Rezoning Transportation Analysis

Petition Number: 2020-105
General Location Identifier: 08108415

Revision Log:	Date	Description
	08-19-20	First Review
	09-22-20	Second Review
	10-20-20	Third Review

RZ-1.0

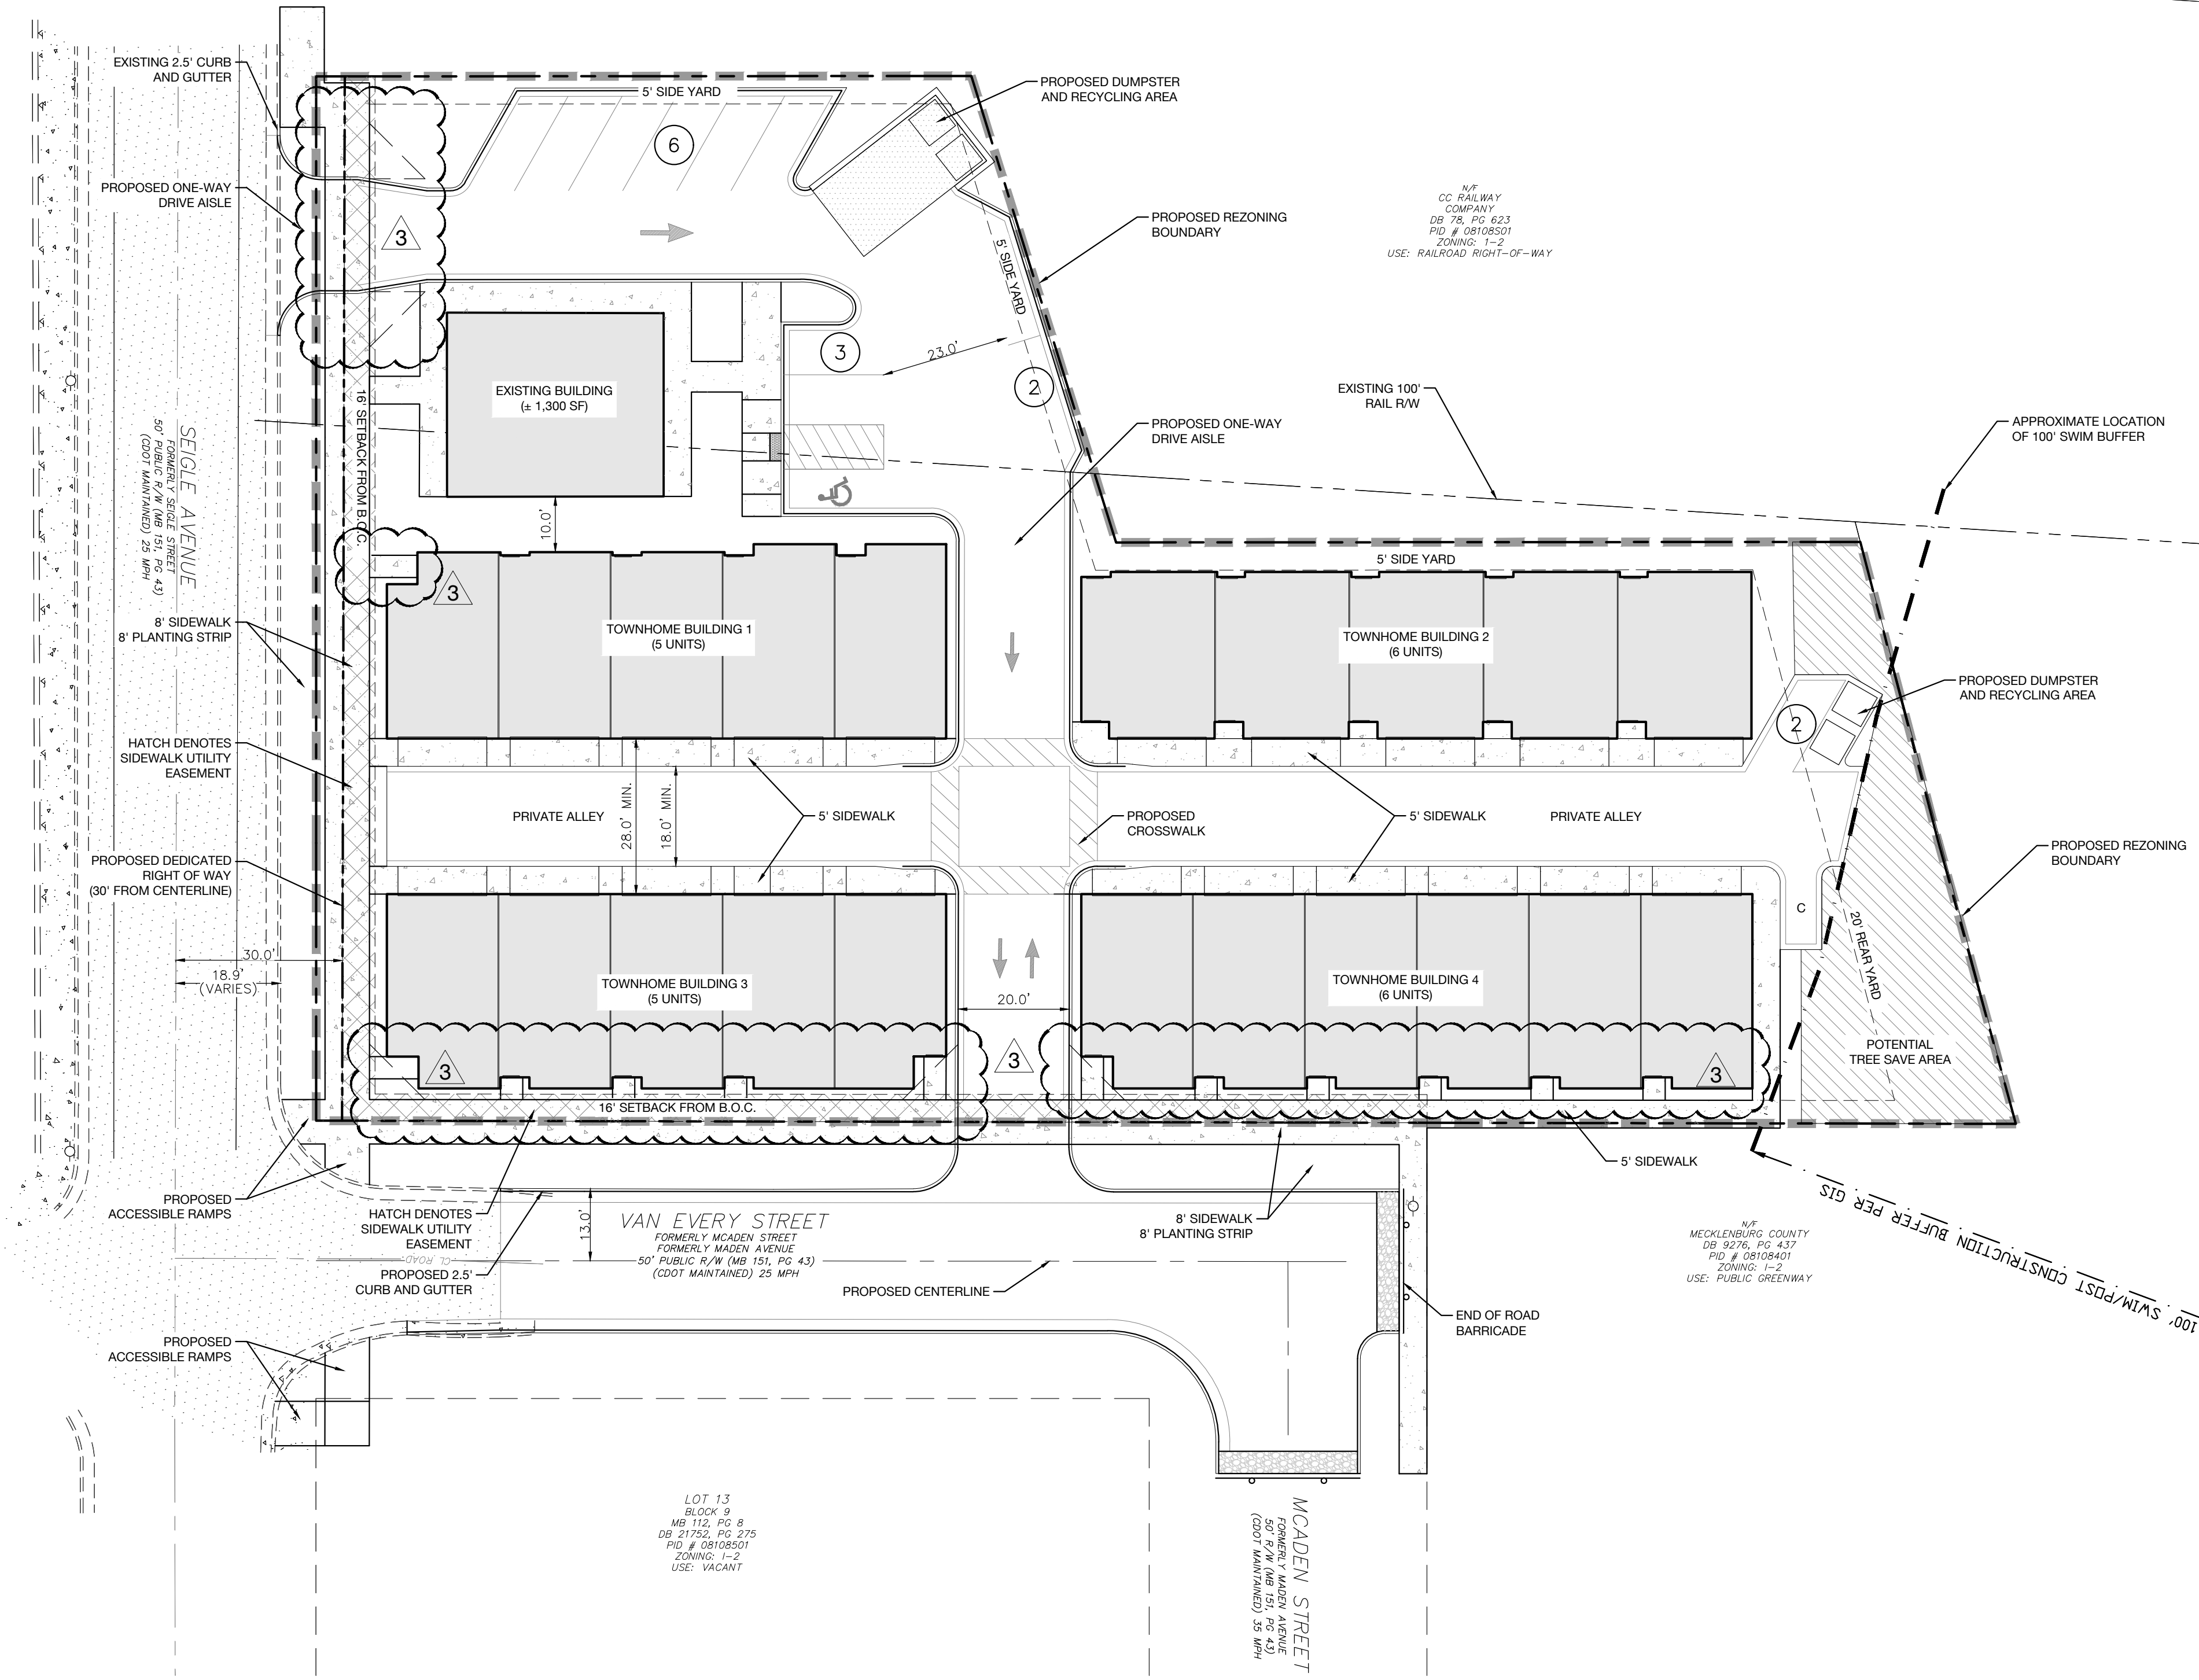
~~The site plan should show the curb and gutter labeled and dimensioned from the centerline for each road.~~

3. ~~The petitioner should revise the site plan and conditional note(s) to commit to dedicating a minimum of 30' right-of-way from the road centerline. The site plan should label and dimension the right-of-way from the road centerline.~~

~~The site plan should label the 30' right-of-way from the road centerline along Seigle Avenue.~~

~~The petitioner should revise the site plan and conditional note(s) to convert the driveway on Seigle Avenue, the drive aisle, and the diagonal parking along the drive aisle, to a one-way ingress only.~~

4. ~~The petitioner should revise the site plan and conditional note(s) to reconstruct two curb ramps on the north quadrant of the Seigle Avenue/Van Every Street Intersection in accordance with PROWAG and the ADA law.~~
